Response to Department of Planning Comments

Key Issue 1 Building form and design - Building 1
Further consideration should be given to options that reduce the actual or perceived east I west length of Building 1, including architectural design features, recesses and building articulation. Further consideration should be given to the internal arrangement of building 1 to increase activity on the north and south facades, including further consideration given to: — how the car park, plant and two cores on the north elevation could relate more positively to the desired 'high street' character of Central Avenue and the orientation of the Channel 7 building; and — how the car park on the south elevation could provide an active facade to the adjacent public domain. In addition to the proposed building height coordinates requested by Sydney Airport, please provide further clarification of any potential impacts of the building should it enter protected airspace.

Key Issue 2
Building form and design - Building 2

Elevations - North & West

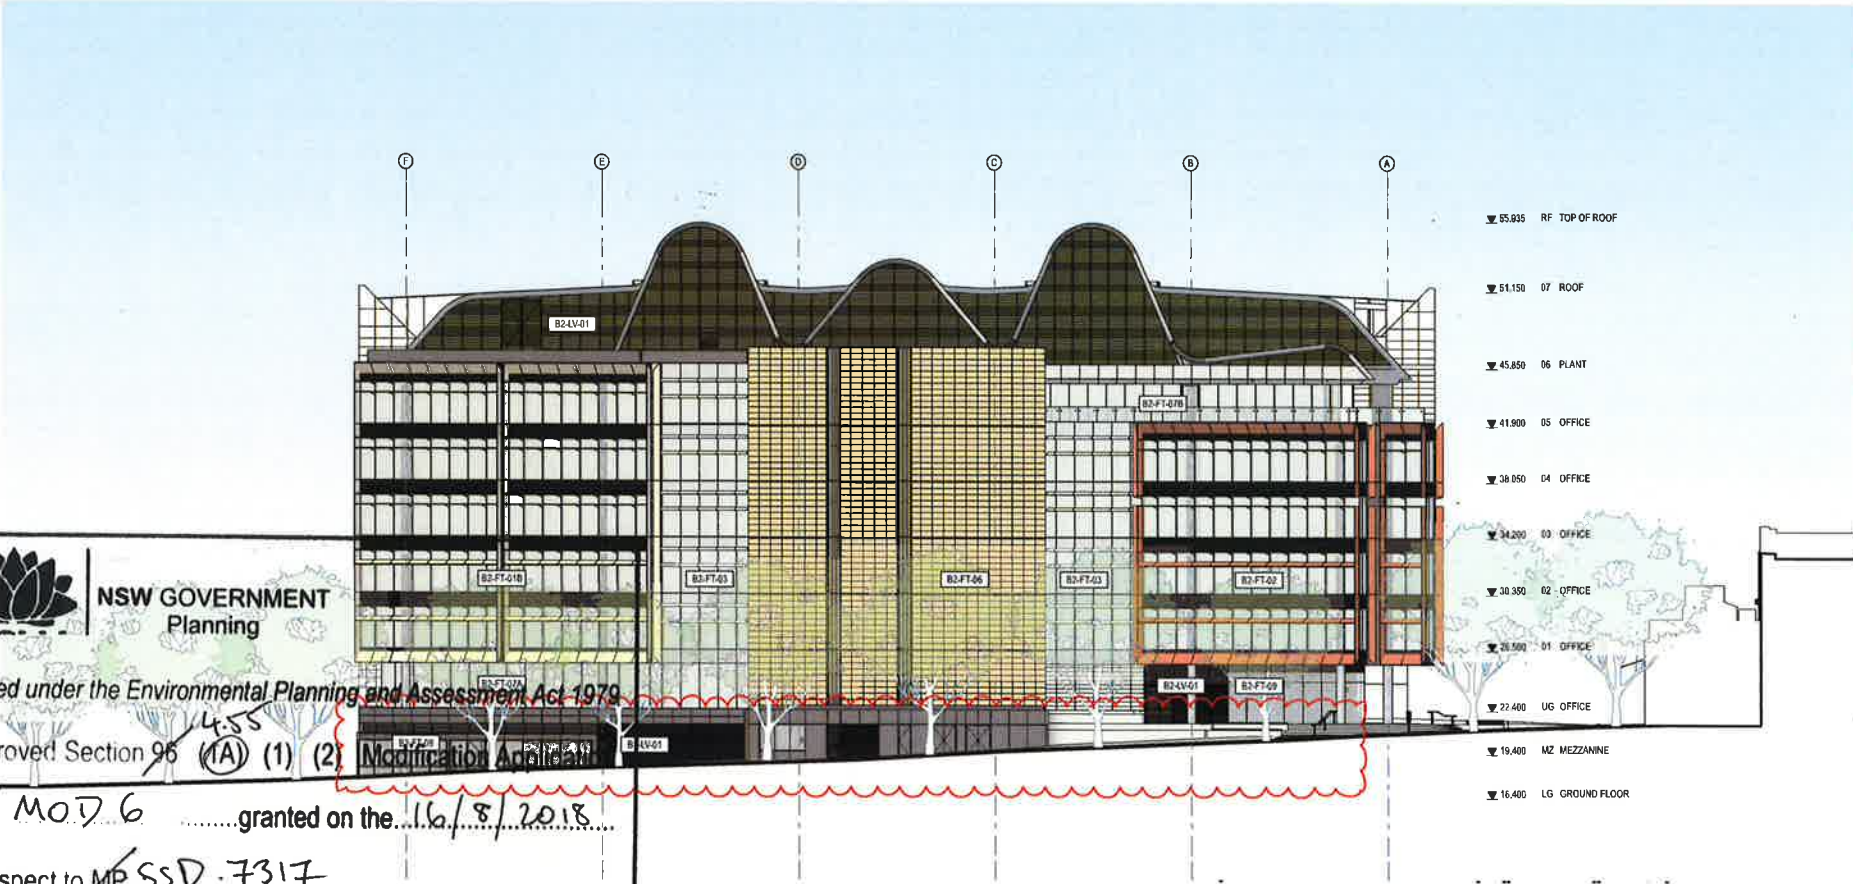
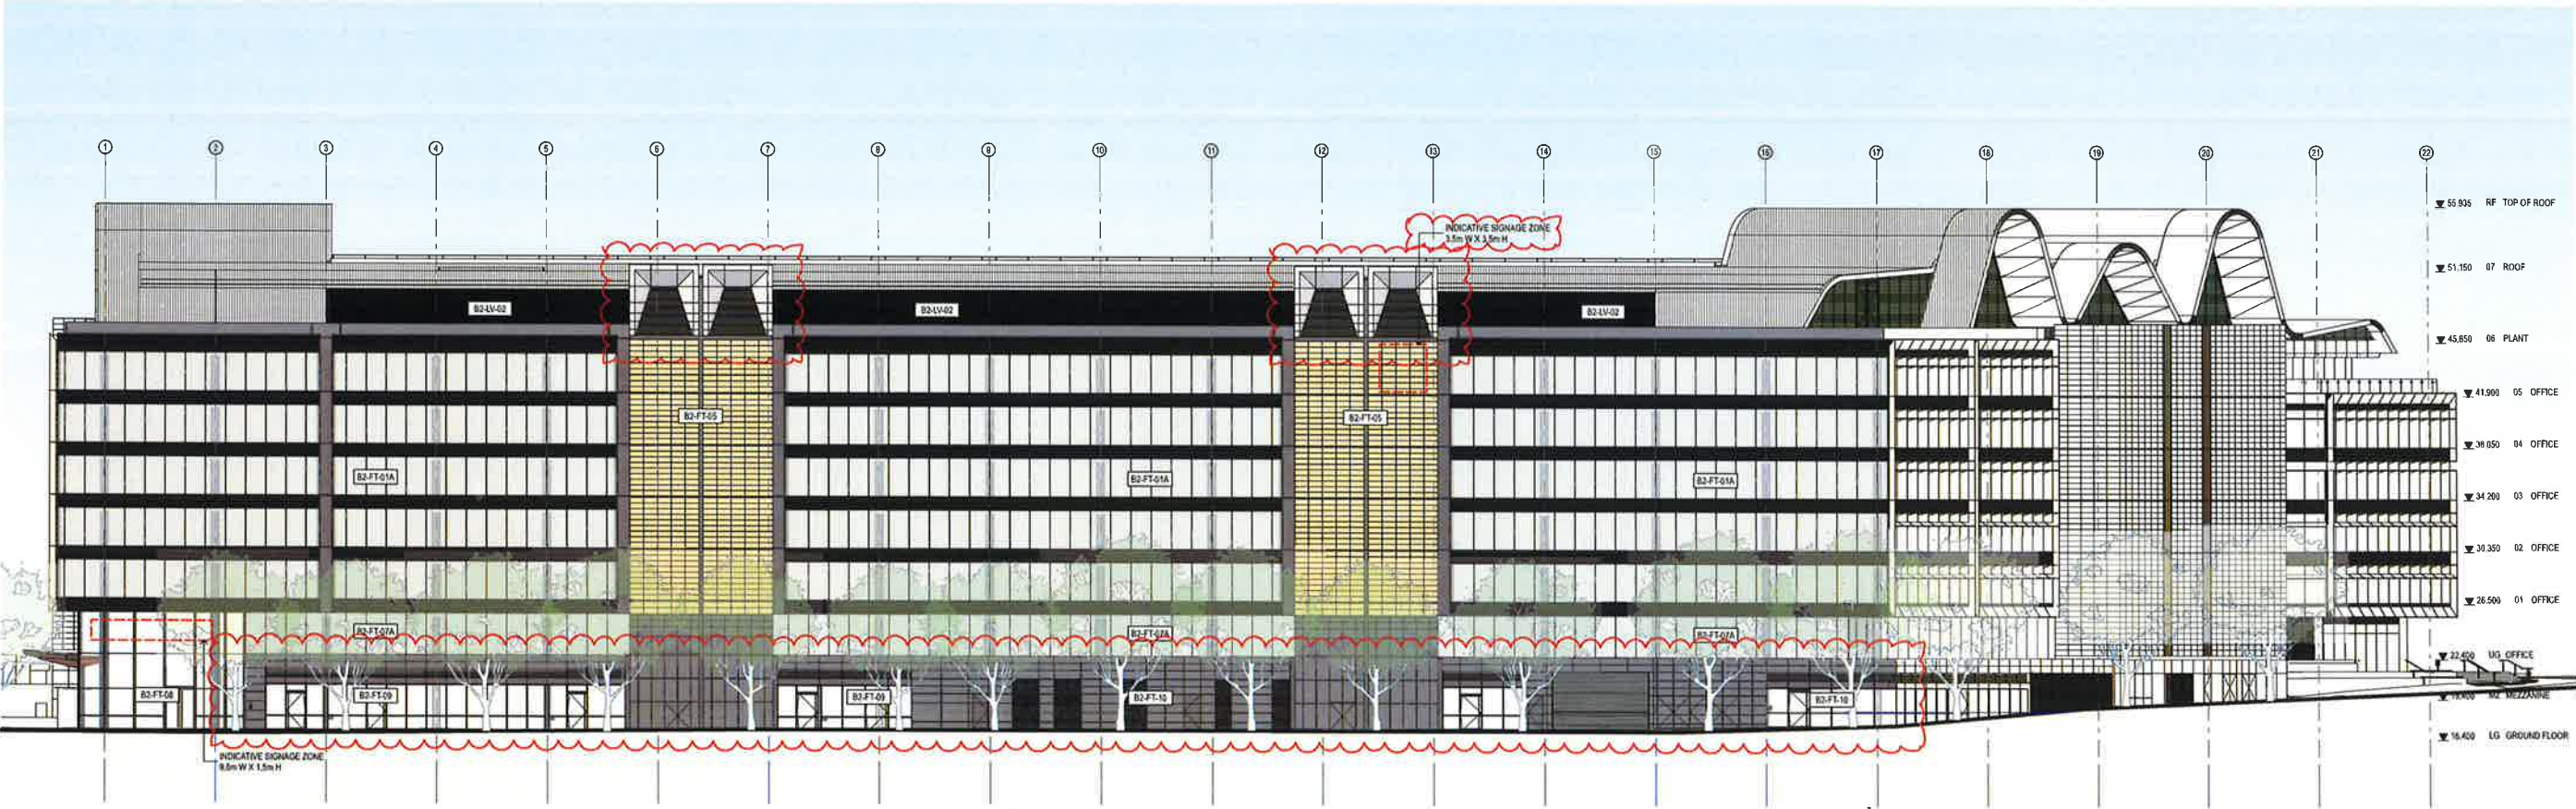
Further consideration should be given to options that reduce the actual or perceived east-west length of Building 2, including architectural design features, recesses and building articulation.

Provide further clarification on how the two entrances to the commercial component relate to each other, and in particular the impact on legibility for visitors to the building.

A comparison analysis between the north facade of B2 and the adjacent Locomotive Workshop facade has been undertaken and is included on the following page of this report. This analysis illustrates how the north facade of B2 is broken into 9 primary facade bays. Each bay is subsequently further articulated as a series of smaller modules, eg: the glazed workplace bays sit above a recessed ground level and are articulated as two vertically stacked framed elements. The horizontal break between the lower and upper elements has been positioned such that it relates to the top of the Locomotive Workshop gables. Within each frame, an additional level of articulation is provided via carefully detailed and well proportioned shading and spandrel elements.

The comparison analysis illustrates that the overall scale and modulation of the B2 north facade is appropriate and sympathetic to the scale and modulation of the Locomotive Workshop. It will be strongly expressed built form that will reveal the uses within, scaled appropriately to its unique surroundings.

Additionally the comparison analysis illustrates the relationship between the main B2 entry and the major glazed entry to the Locomotive Workshop. The main B2 entry is co-located with the glazed entry to the Locomotive Workshop with a slight but deliberate offset in plan. The offset ensures that the entrances have a relationship and can collectively define a central activated zone along Locomotive Street whilst not creating an overall formal relationship. This relationship is further illustrated in the 3d sketch views that follow.
